**From:** Holly Duncan  
**Sent:** Tuesday, October 04, 2011 3:57 PM  
**To:** Jeff Watson  
**Subject:** RE: BL-11-00024 Otte

**From:** Jeff Watson  
**Sent:** Tuesday, October 04, 2011 11:47 AM  
**To:** Christina Wollman; Brenda Larsen; Jan Ollivier; Holly Duncan  
**Subject:** BL-11-00024 Otte

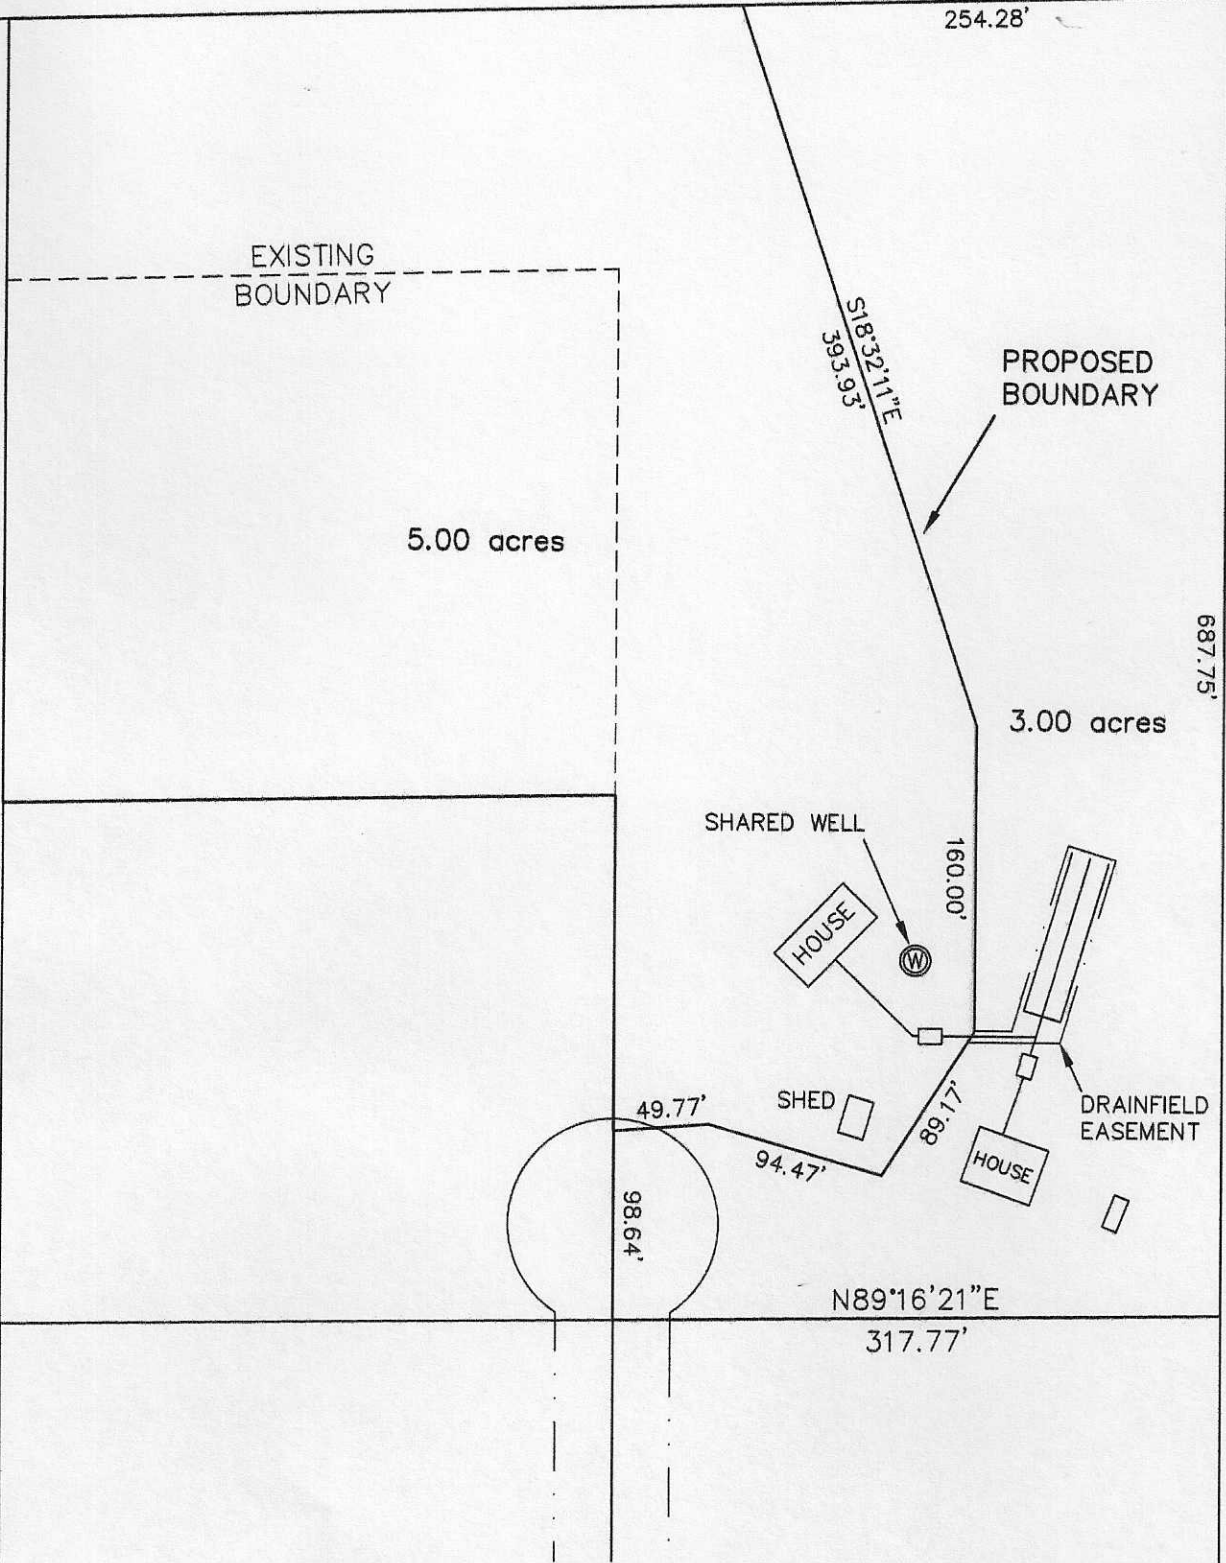
I also have questions on this one. It appears that the proposed project will have a lot line going through the area where the house, well site and drainfield might be. I need a better site plan showing the location of the well and on-site sewage system in relation to the proposed lot line. Can the applicant provide this?
